## RESPONSE TO REVIEW COMMENTS

### **WALDEN PRESERVE 2 – AMENDED PUD DEVELOPMENT PLAN PUD-18-007**

LAND RESOURCE ASSOCIATES

March 11, 2019

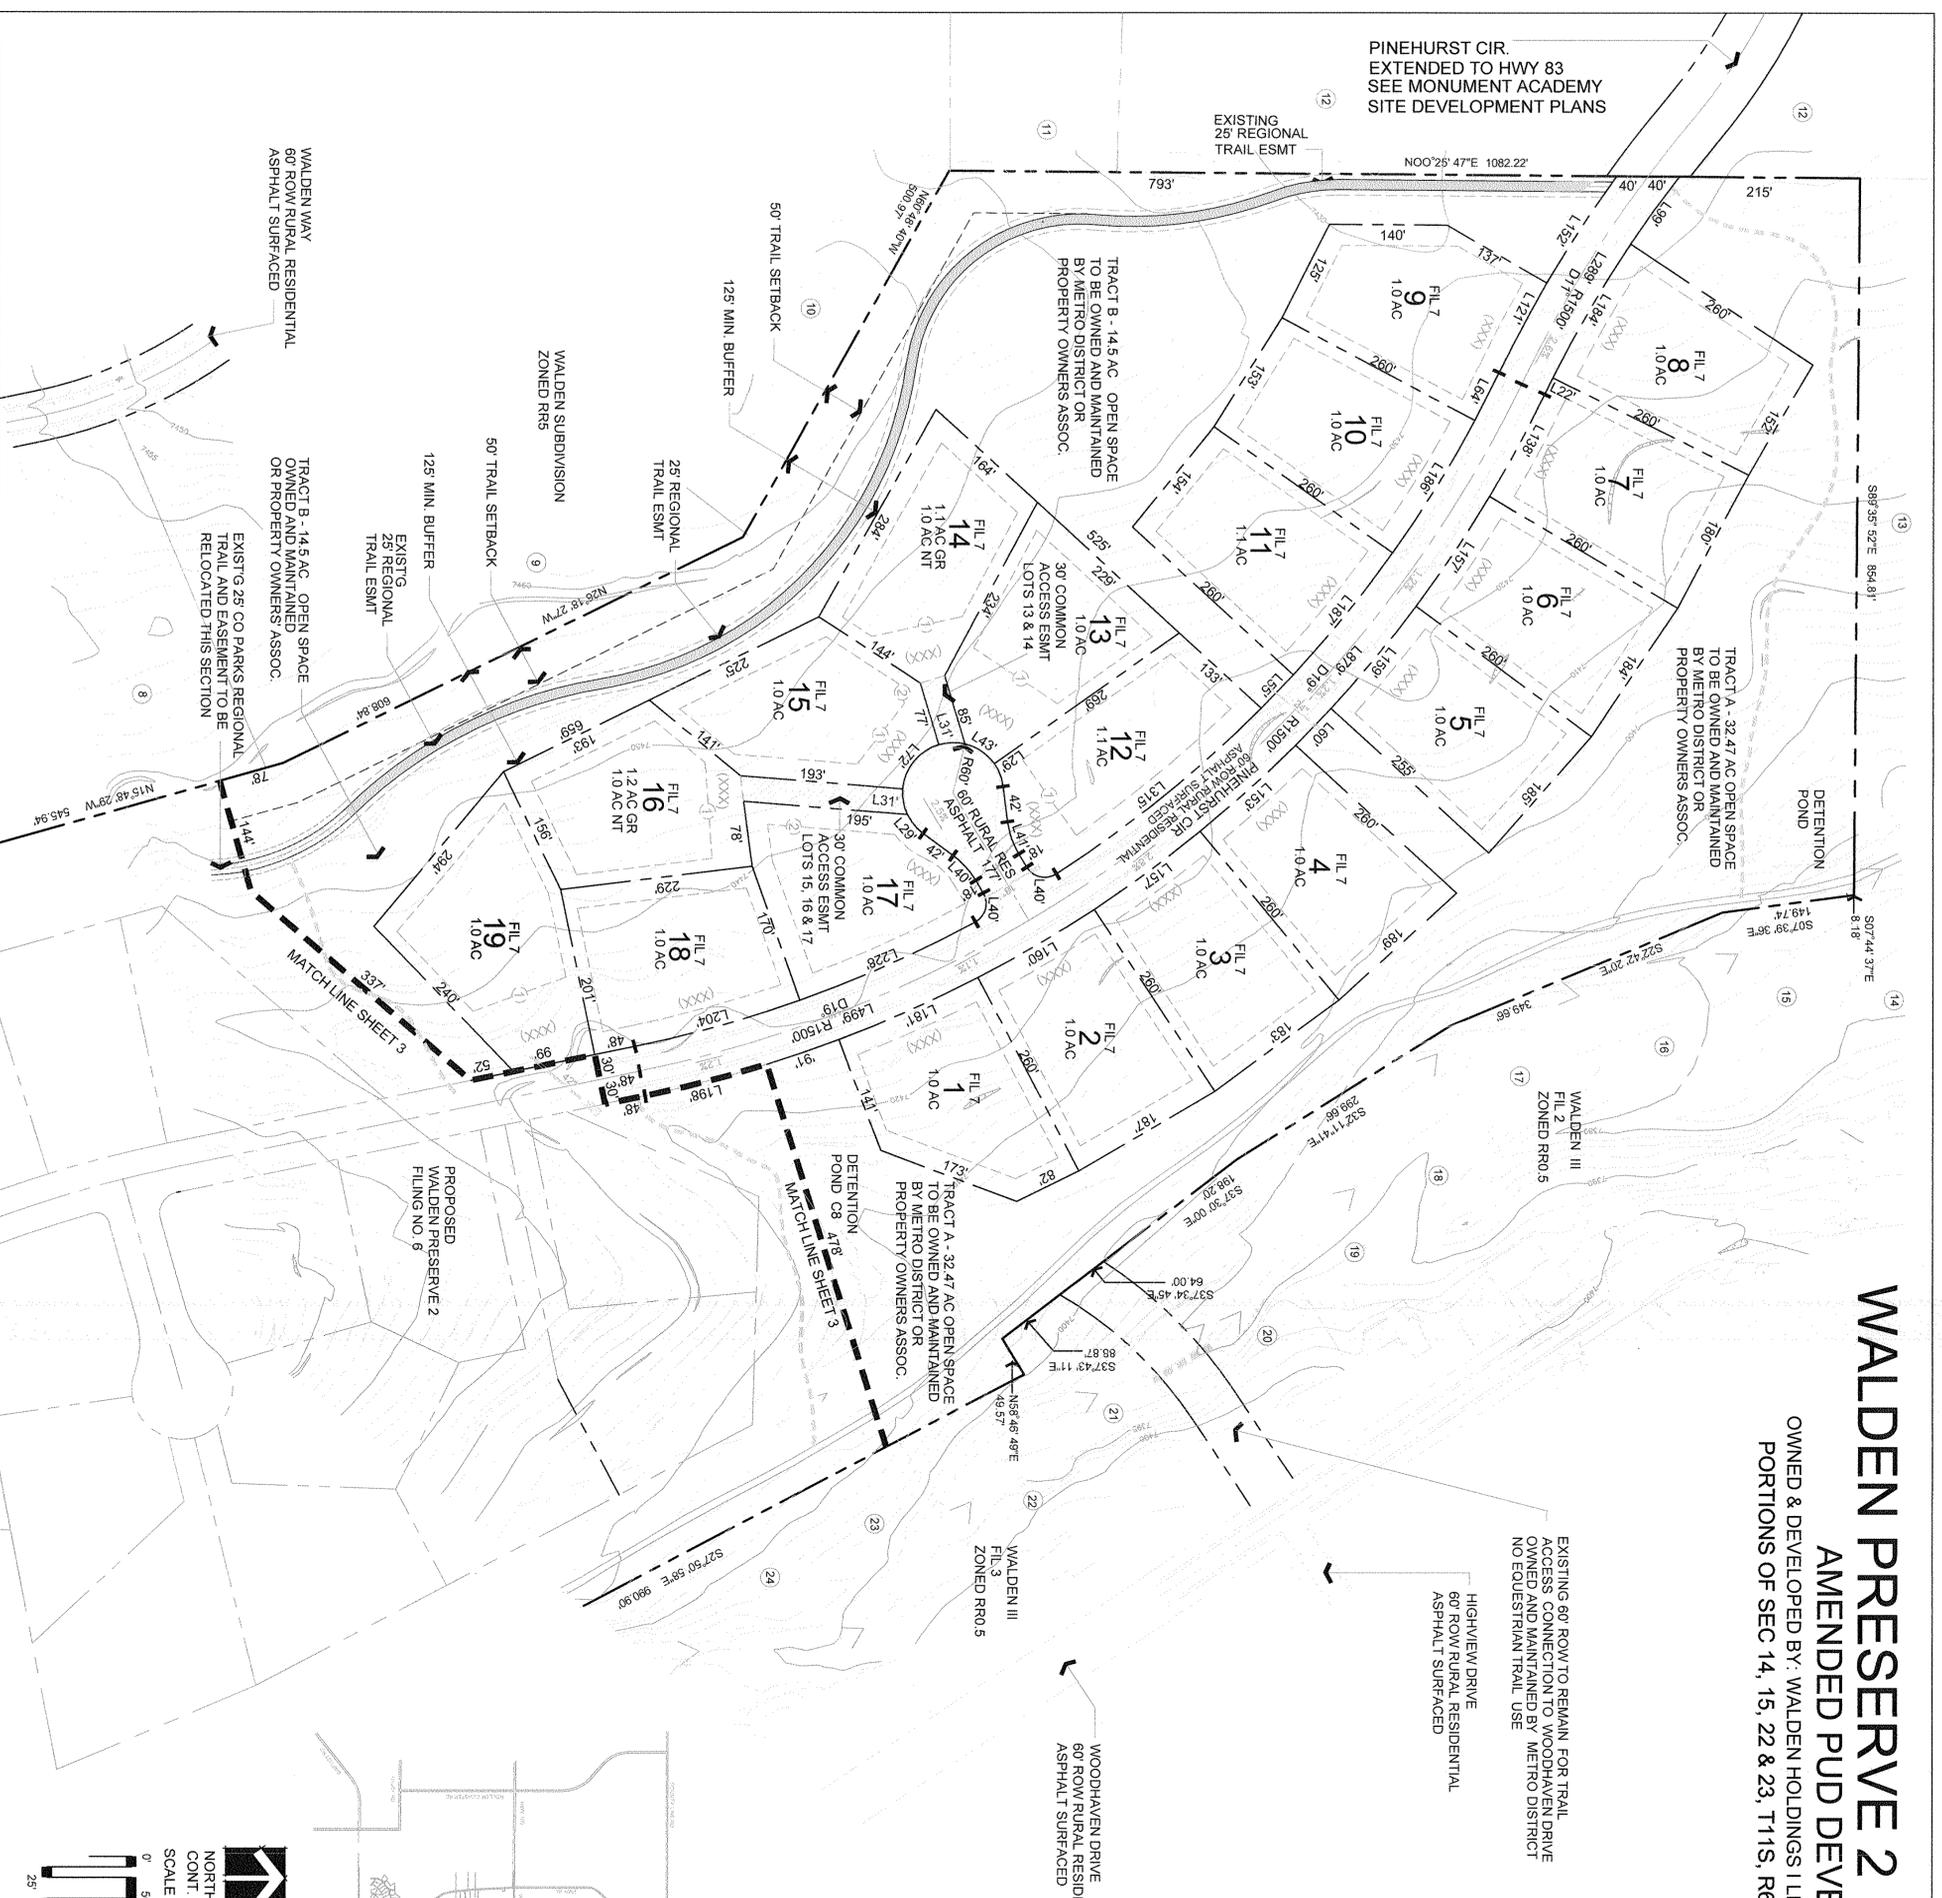
Sheet 4 – *Revise roadway cross section per ECM requirements* – The roadway cross section has been up-dated to reflect aggregate base course daylighting horizontally to the side slope.

<b>LRA</b>	
LAND RESOURCE ASSOCIATES 3500 SOUTH PARKWAY CHERRY PARK, CO 80699 719-684-2288	
SHEET TITLE: FILING NO. 4	
ISSUED FOR: COUNTY REVIEW	DATE: AUG 10, 2018
PROJECT NUMBER:	DRAWN BY: DJJ
COMPUTER FILE:	CHECKED BY:
DATE:	DATE:
SEP 14, 2018	
SHEET NUMBER: 2 OF SIX	
PUD FILE NO.:

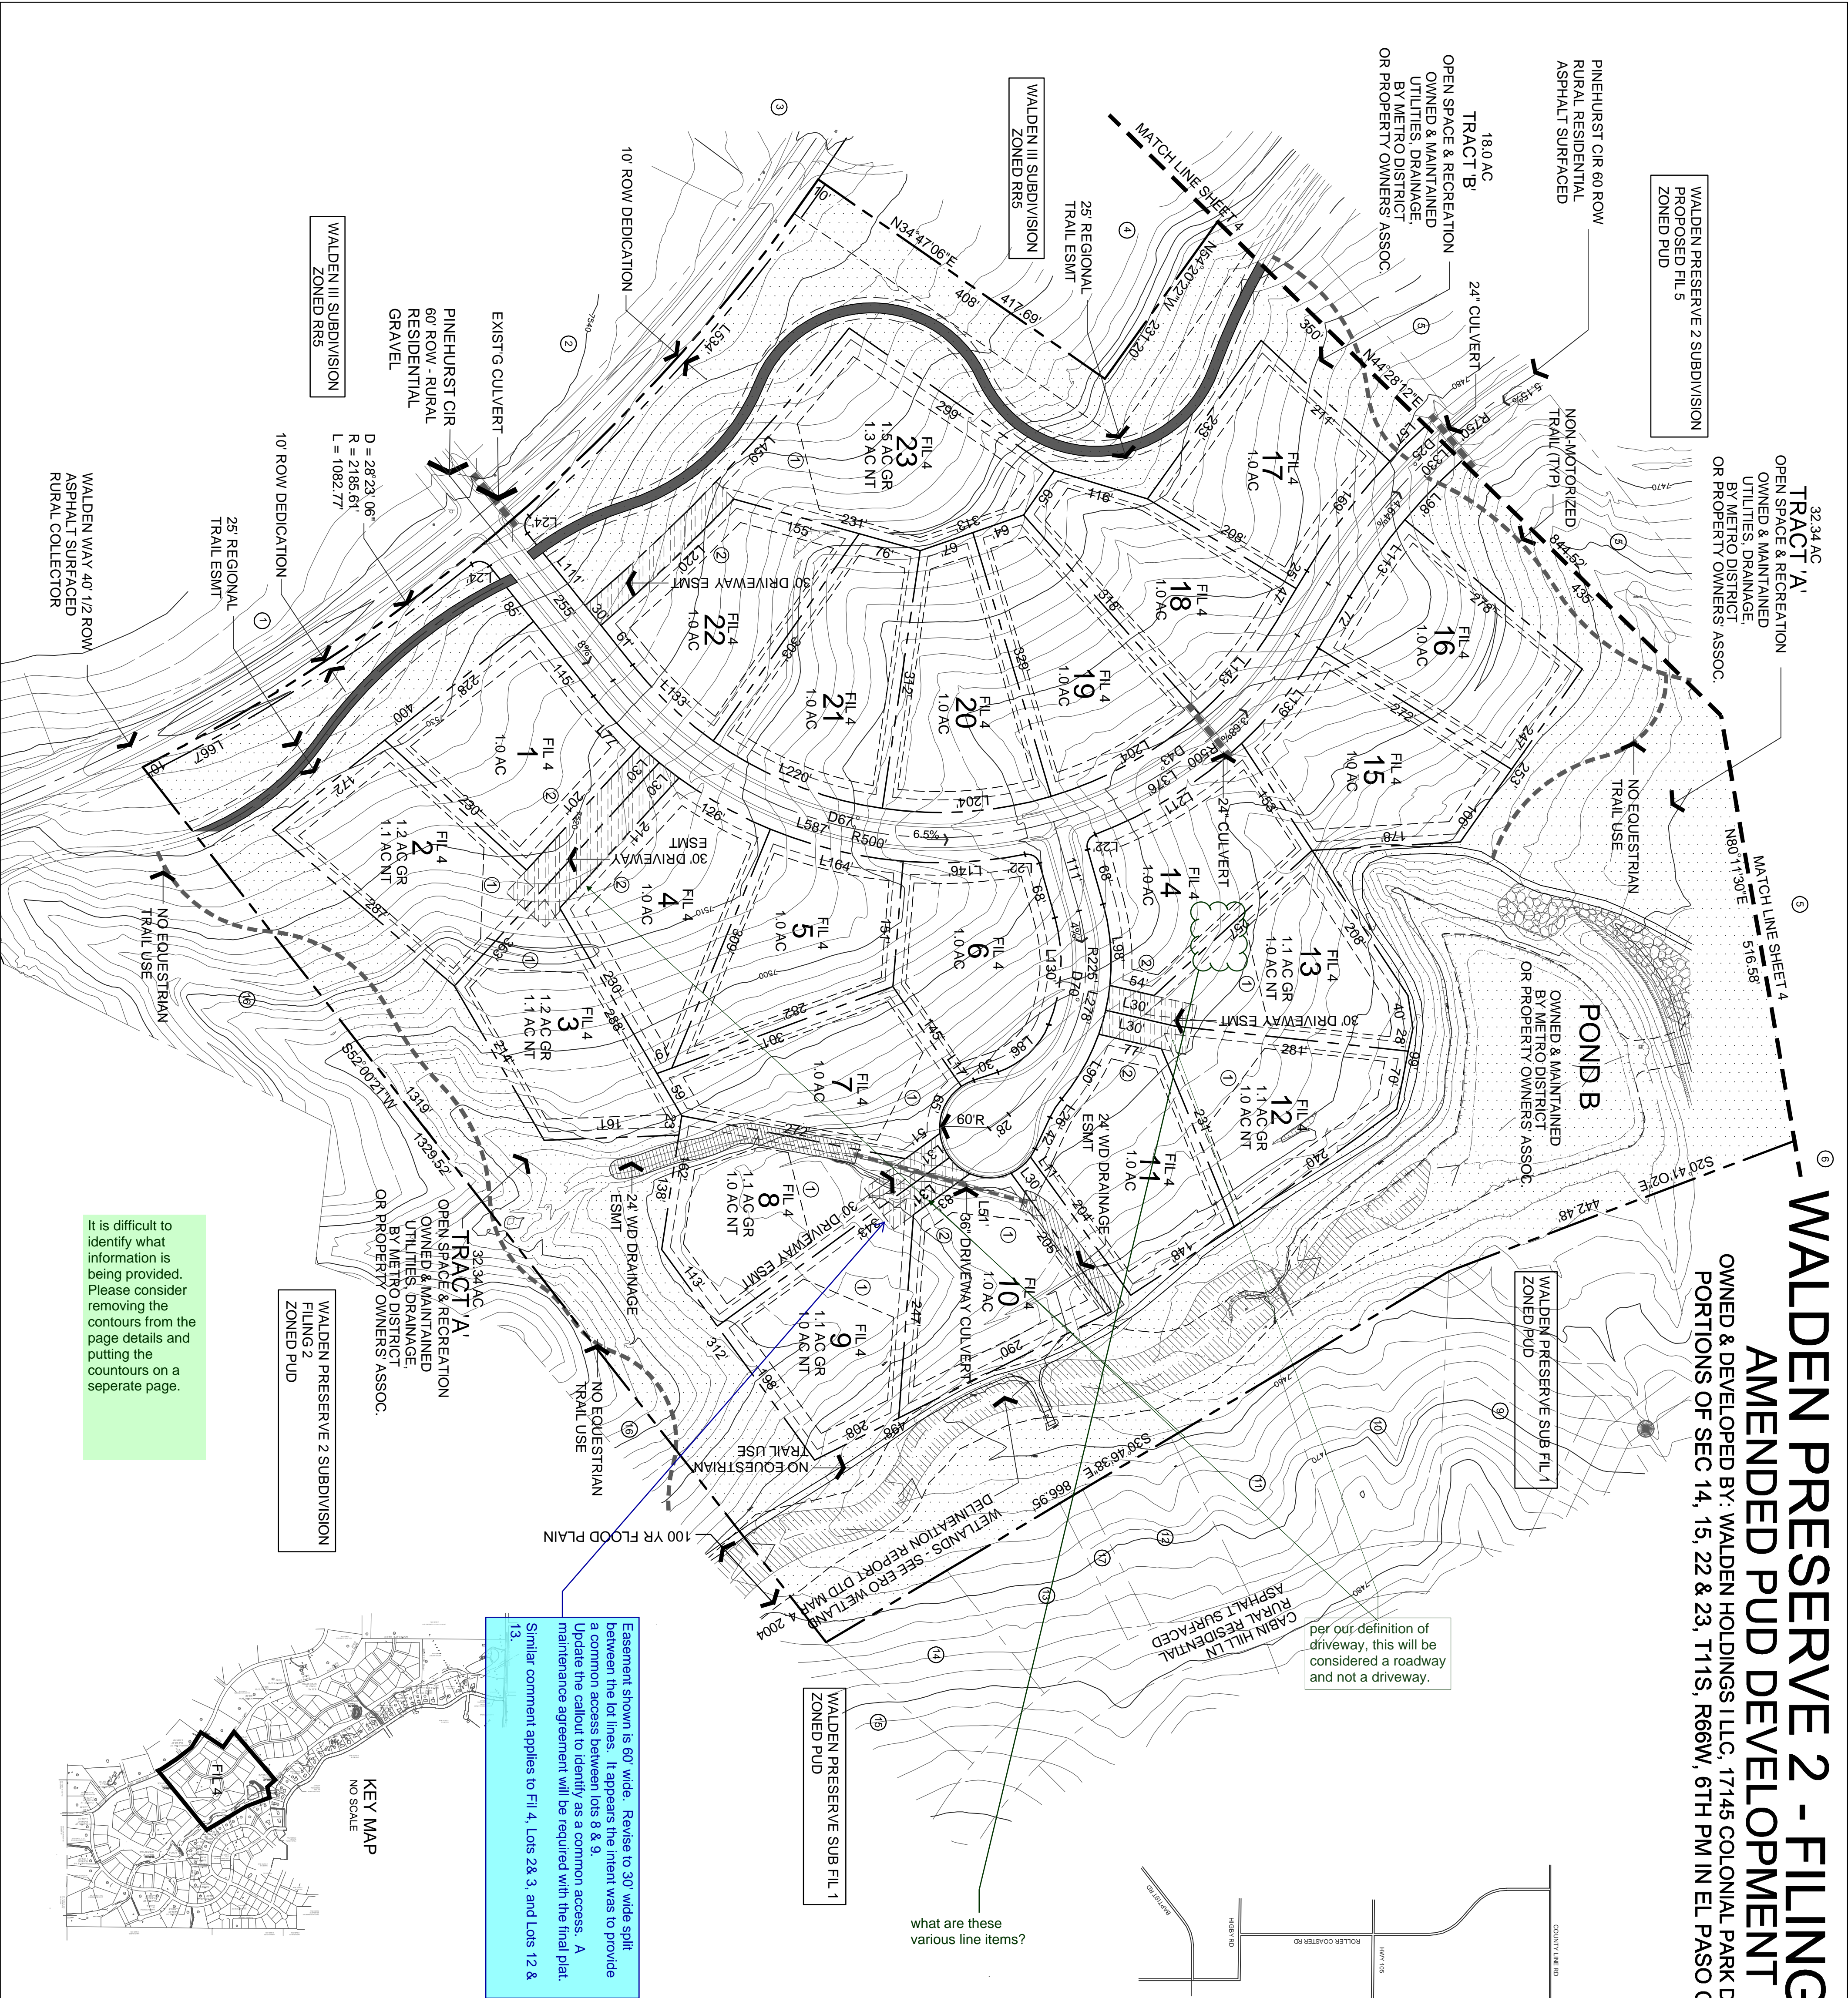
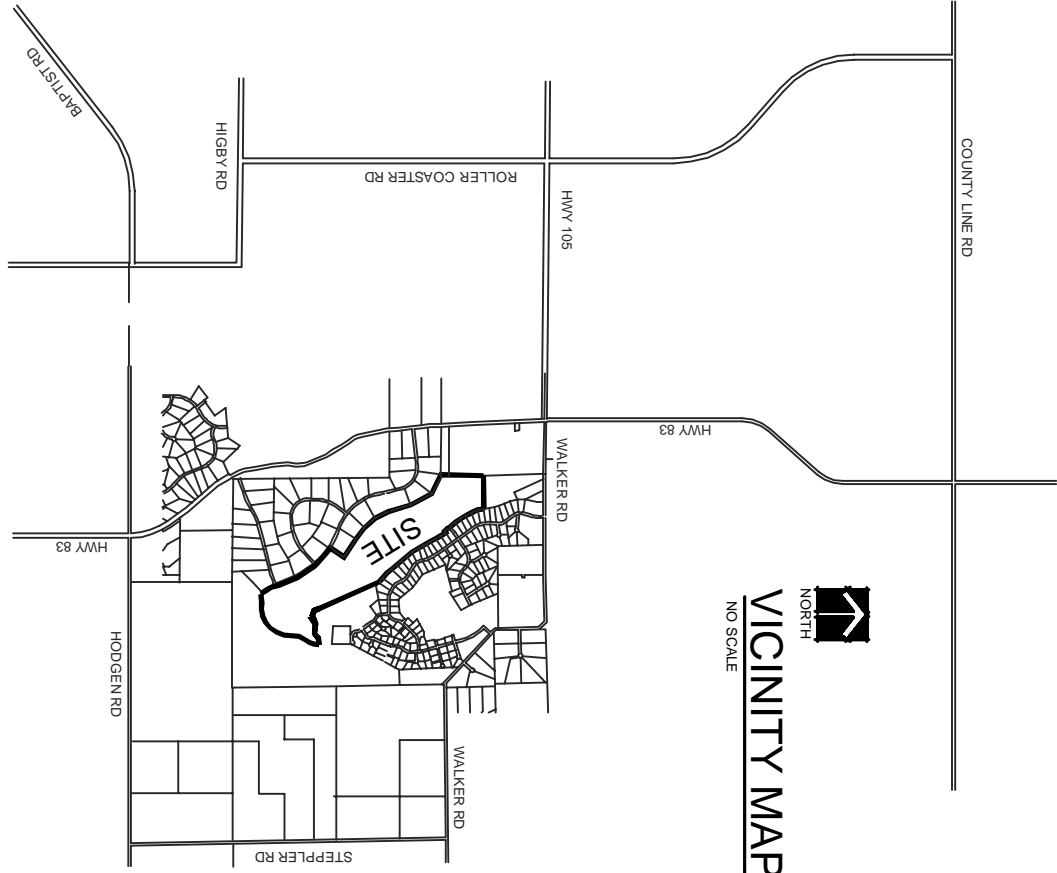
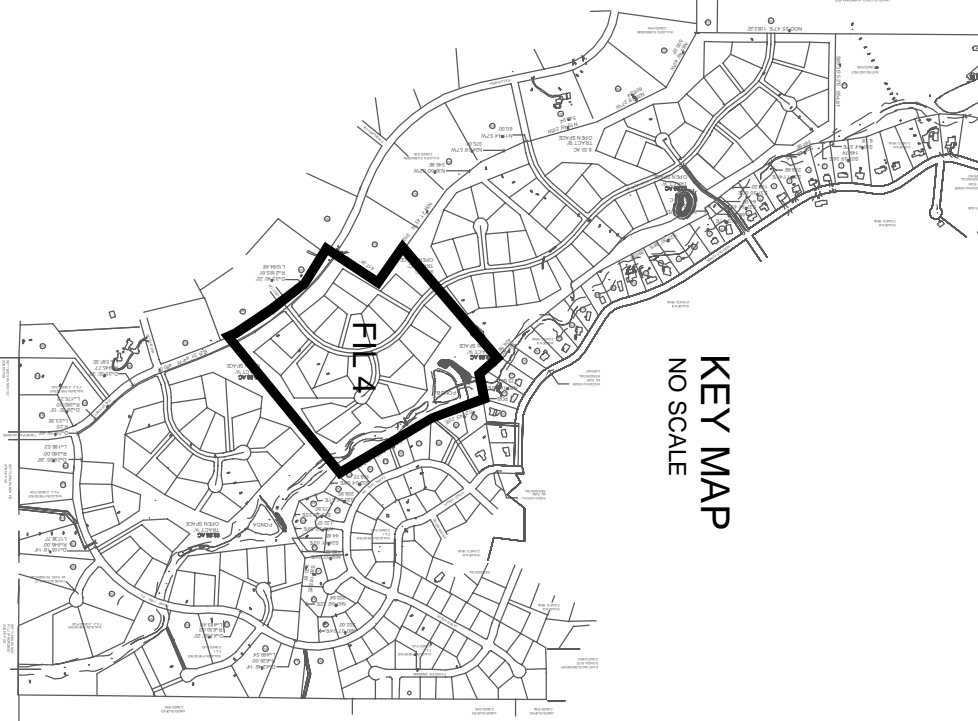
Sheet 2 (and Sheets 3 thru 4) – *It is difficult to identify what information is being provided* – In an effort to clarify the plans; (1) the contours have been significantly lightened, (2) the hatch lines have been lightened, (3) standard lot line easements have been removed in favor of a plan note identifying all standard lot line easements, (4) building setback lines have been lightened.

Sheet 2, 3 and 4 – *issues related to combined access (driveway) easements* – The intent is to provide combined driveway access for up to three lots. Access easements must touch or adjoin any lot being provided common driveway access. Where an easement provides access to 2 lots, the easement is centered on the lot's common property line flag stem and is 30' wide. Where an easement provides access to 3 lots, the access easement is configured such that 30' of the easement width is contained within the flag stem adjoining the non-flag lot being provided access and an additional 15' of width is provided within the adjoining flag stem for a total of 45' of easement width. This technique allows for the actual driveway being centered upon the common flag stem property line while providing legal access to all 3 lots involved. Specific easement locations, widths and lots being accessed by the combined access easement are identified on the Preliminary Plan. Provisions related to common driveway use rights and maintenance requirement and responsibilities are contained within the subdivision's Restrictive Covenants and are consistent with Filings No. 1 through 3. The Walden Preserve 2 Restrictive Covenants are included within this re-submittal package.
